Freedom Forever
Planset Revision Letter

12/3/2024
REV #2

SPENCER RICHARD
44 JACK HARRIS LN

SITE PLAN			
JOB NO:	DATE:	DESIGNED BY:	SHEET:
502646	12/3/2024	A.A.	PV-2

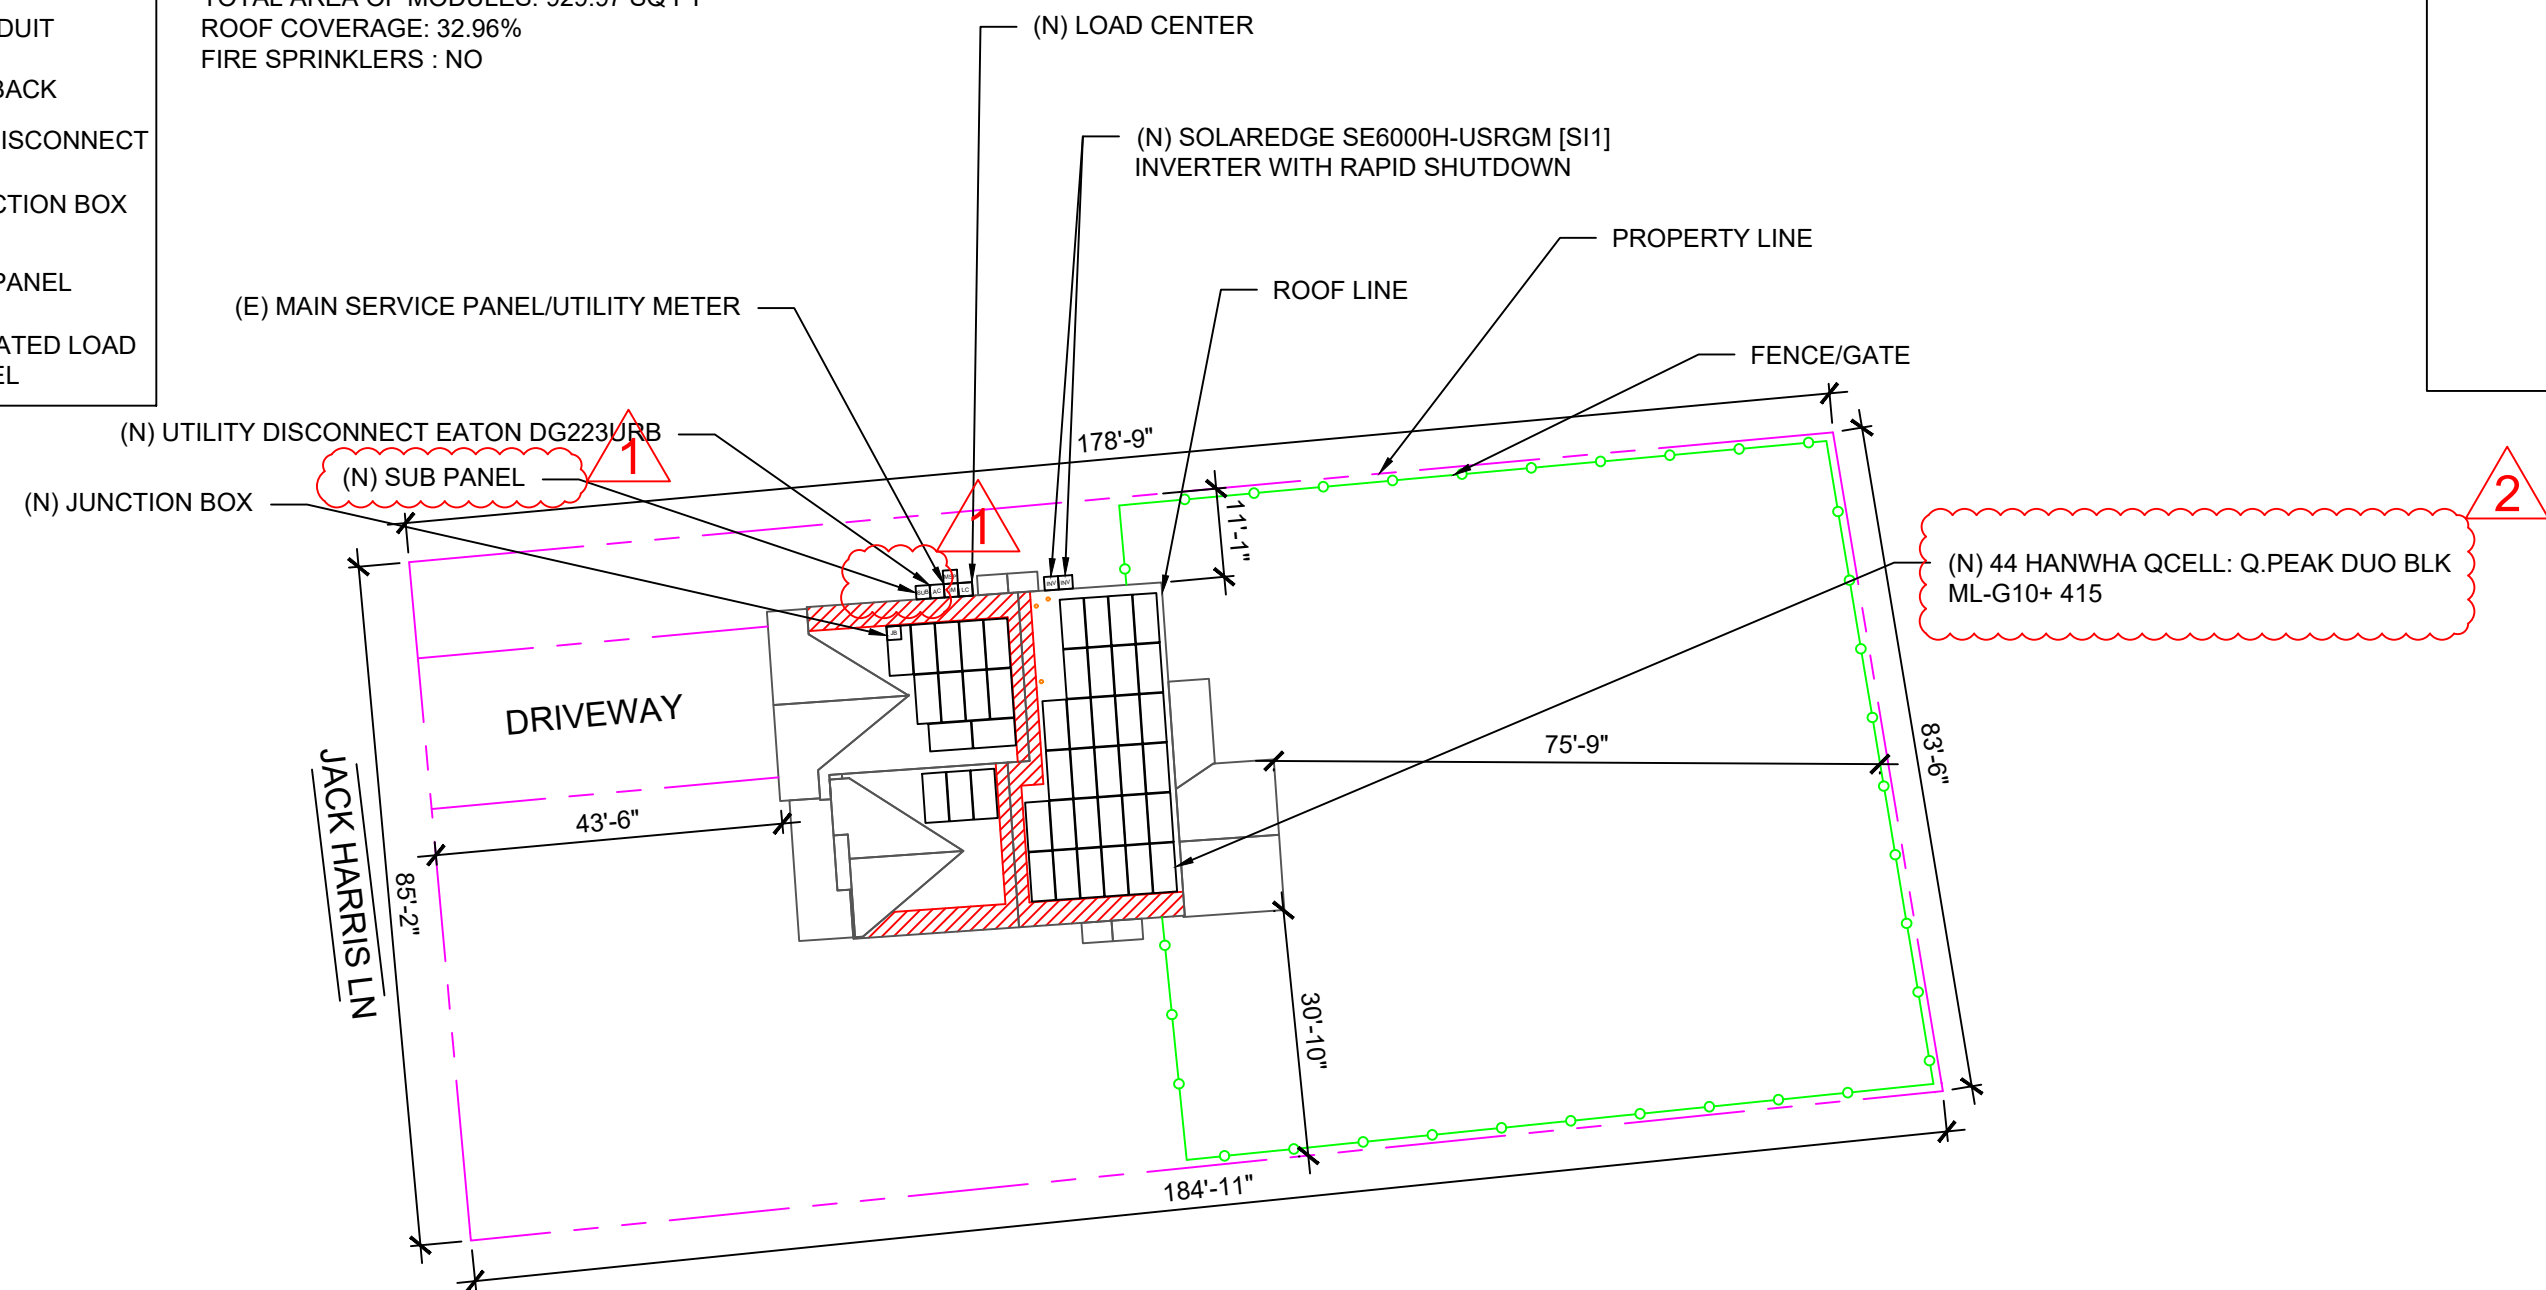
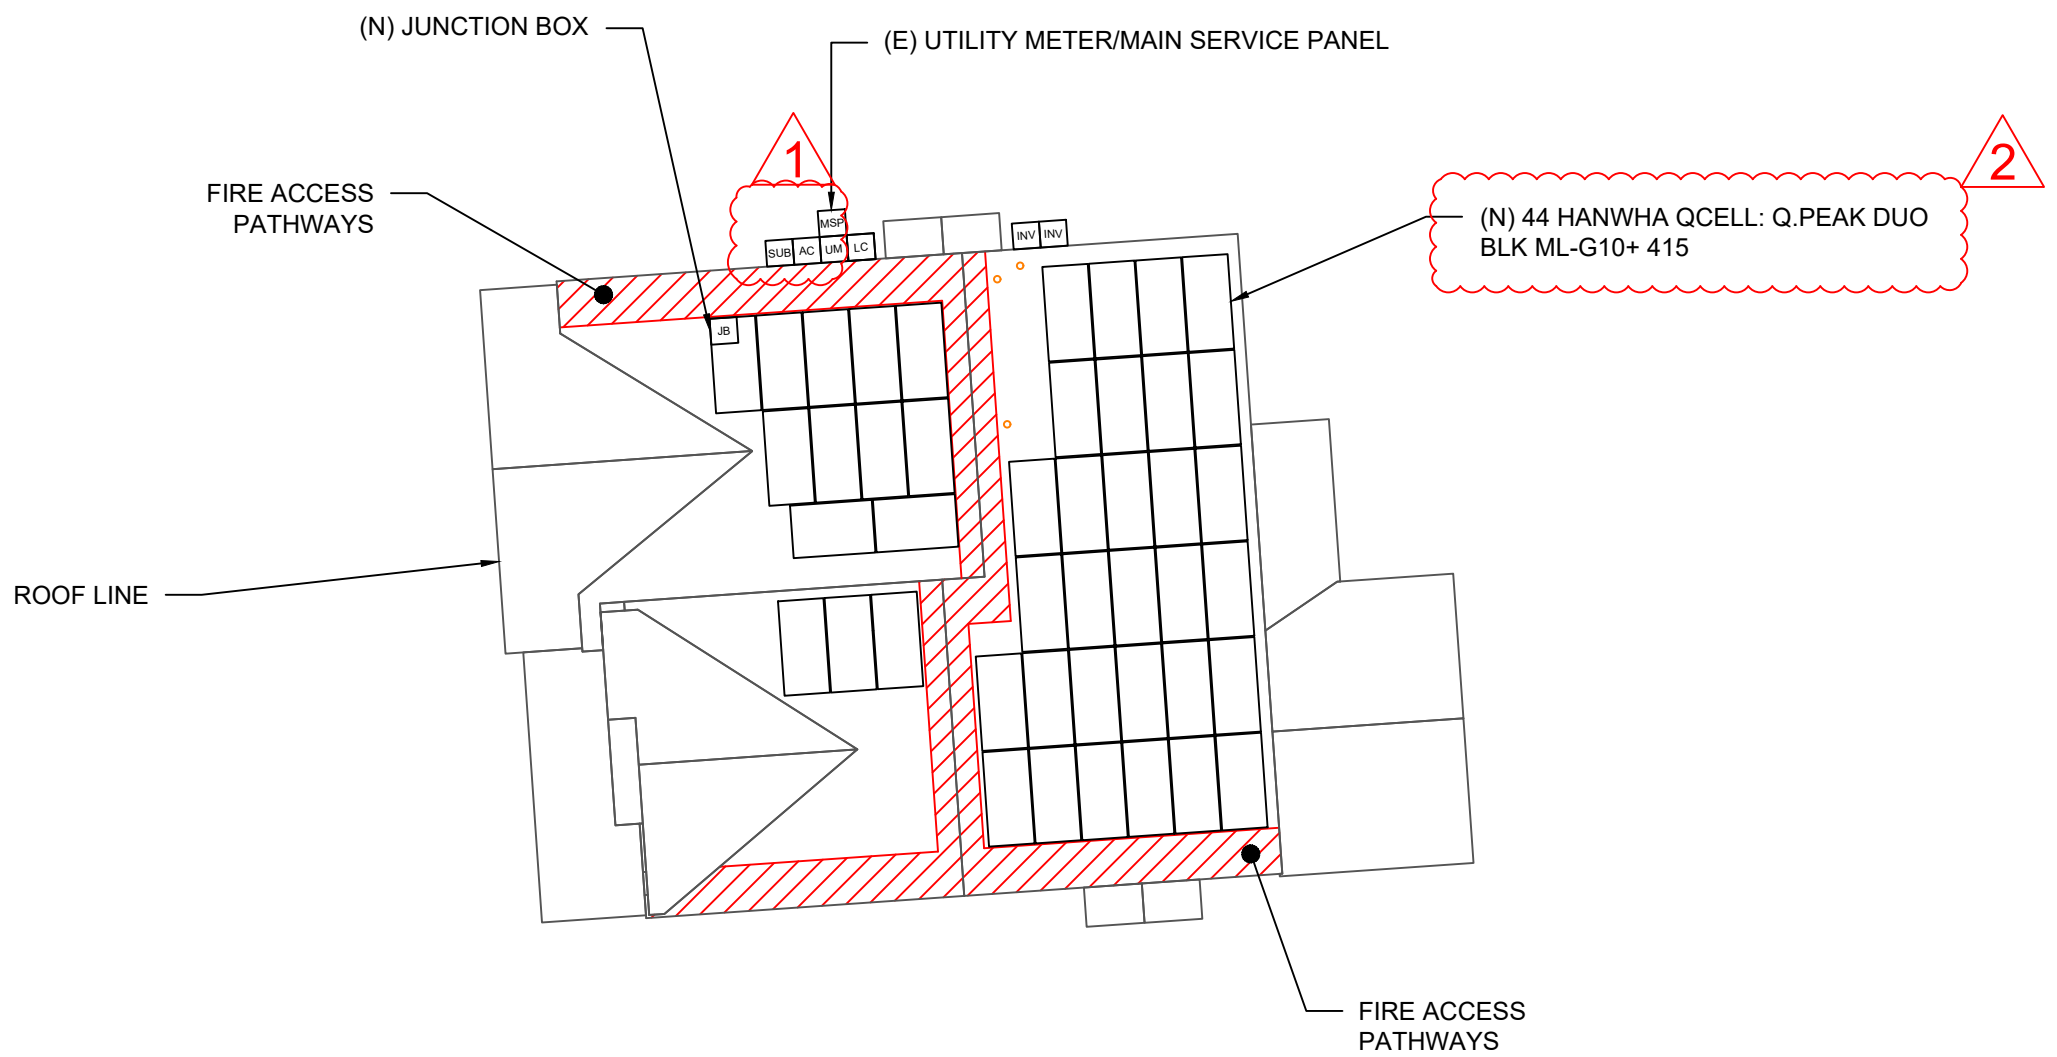
Mod swap to Qcell 415's

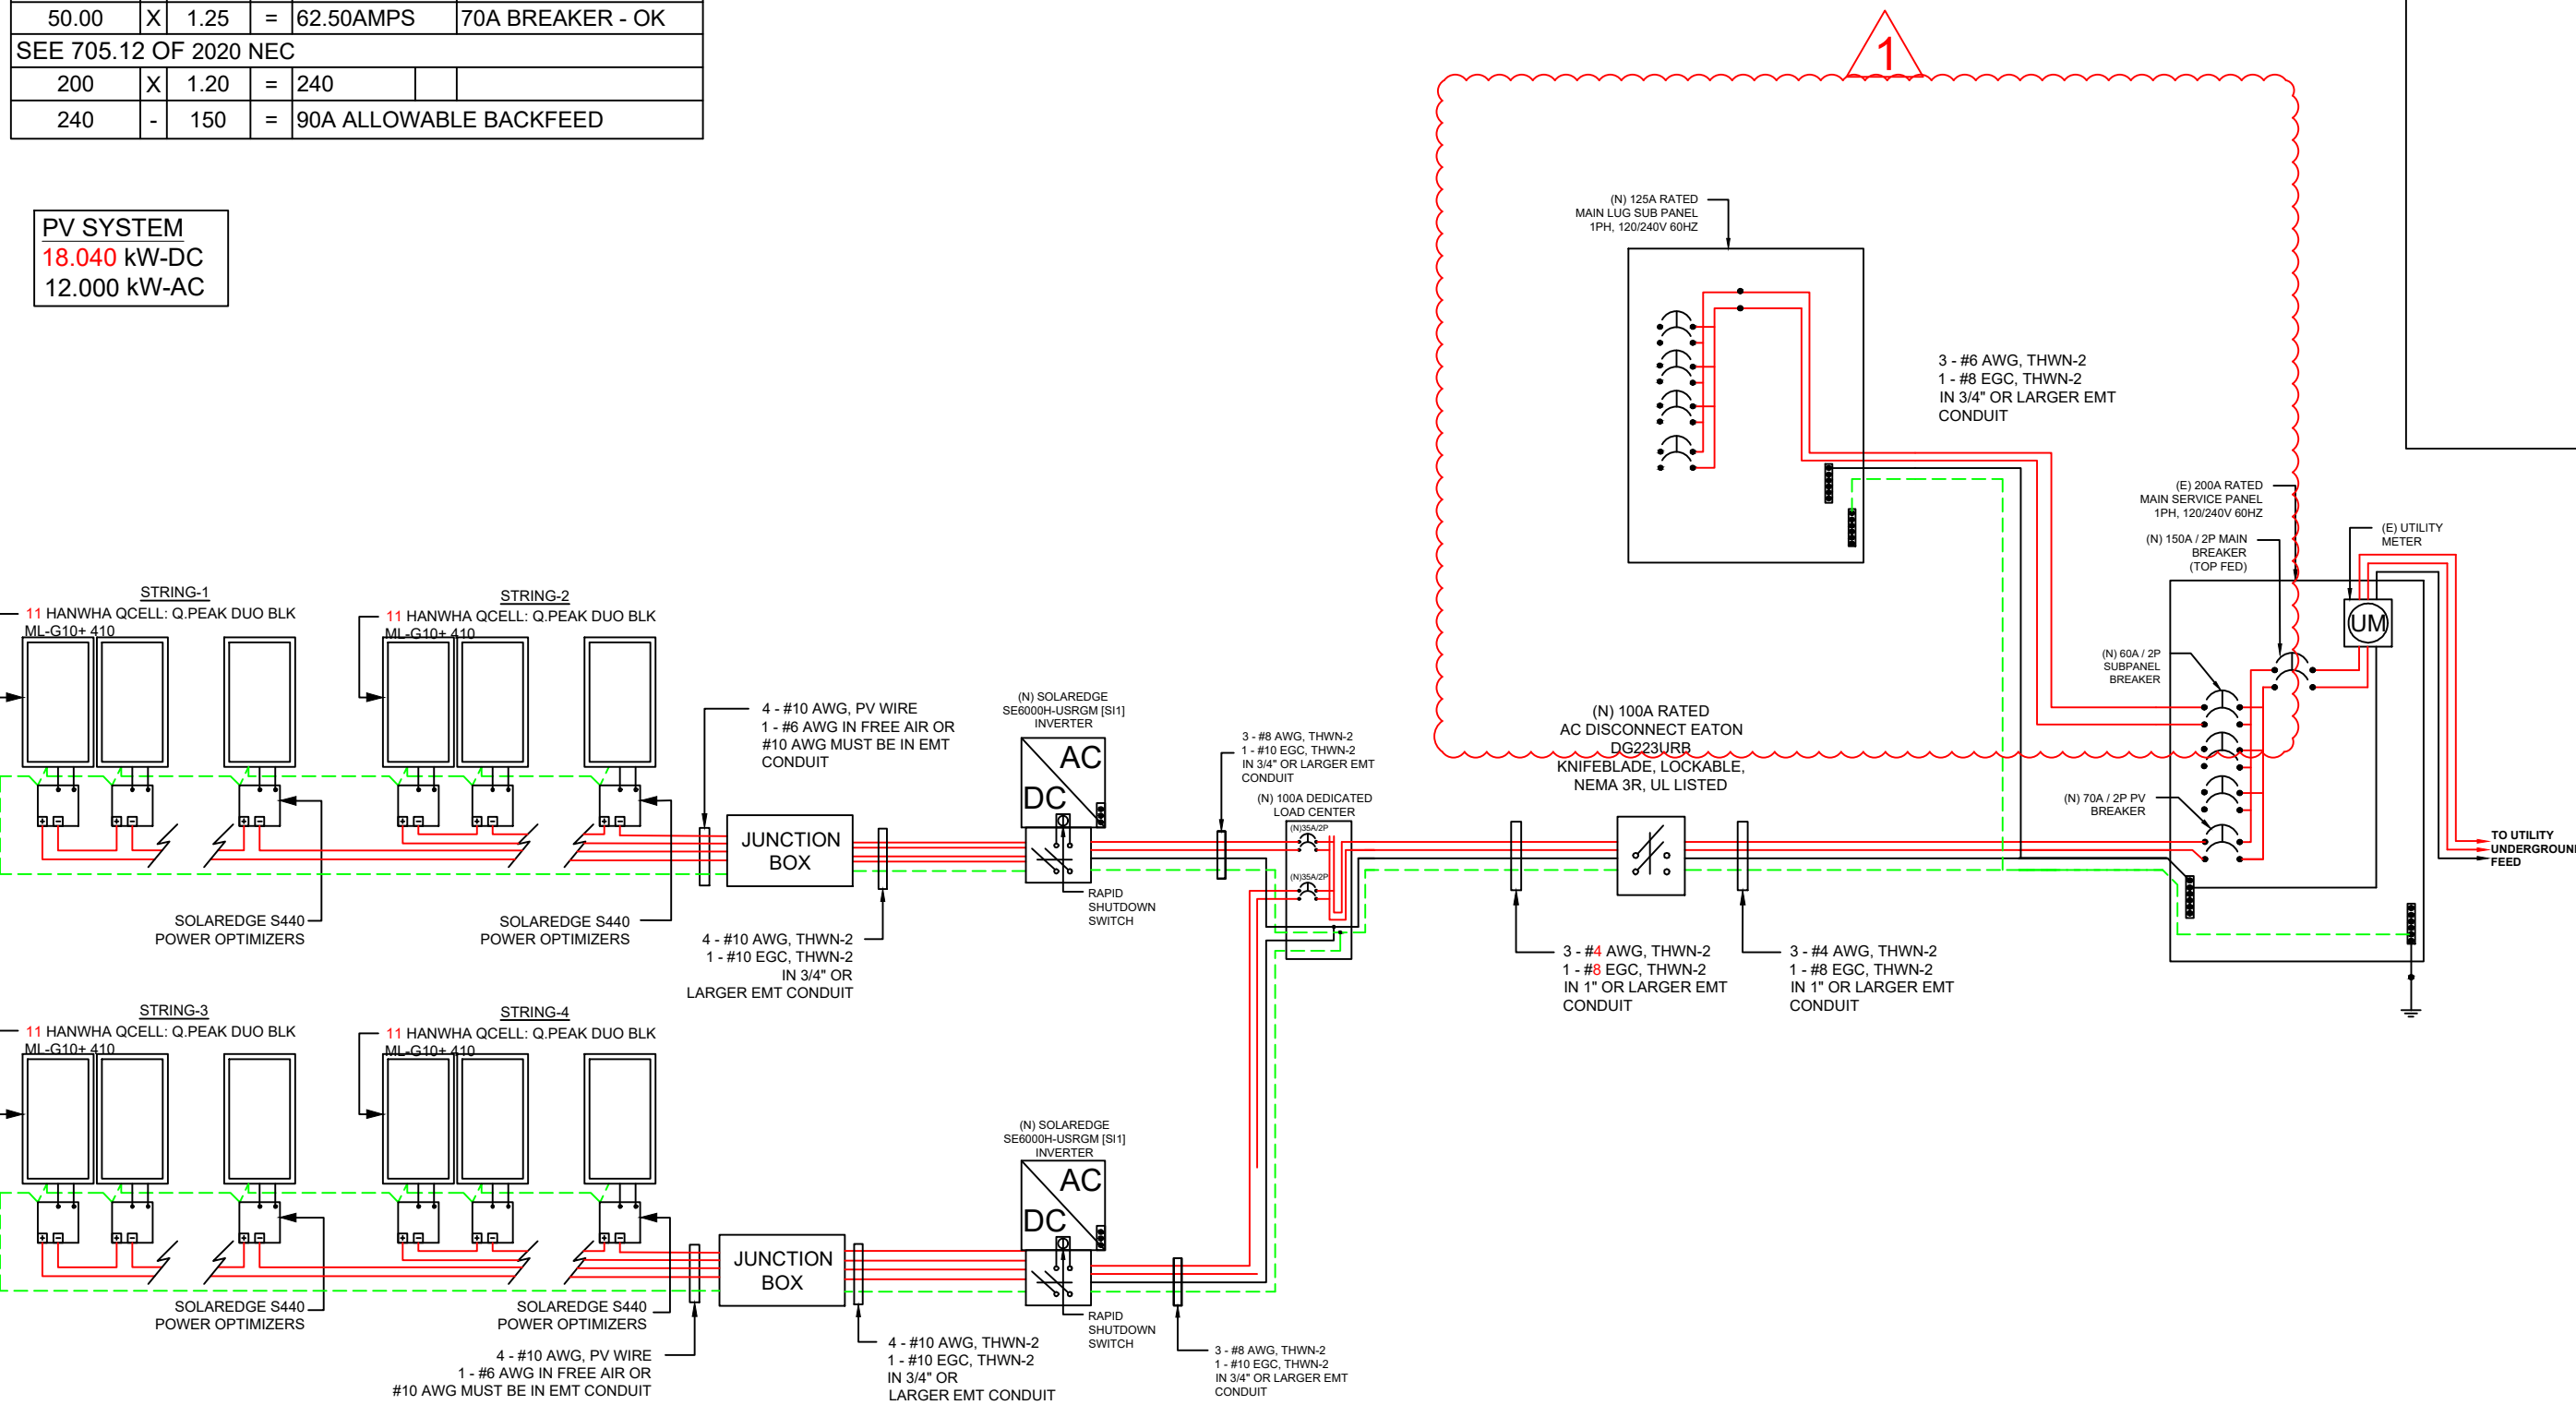
Added New 125A Rated Subpanel Insert/60A Feeder breaker to make room for PV breaker in MSP
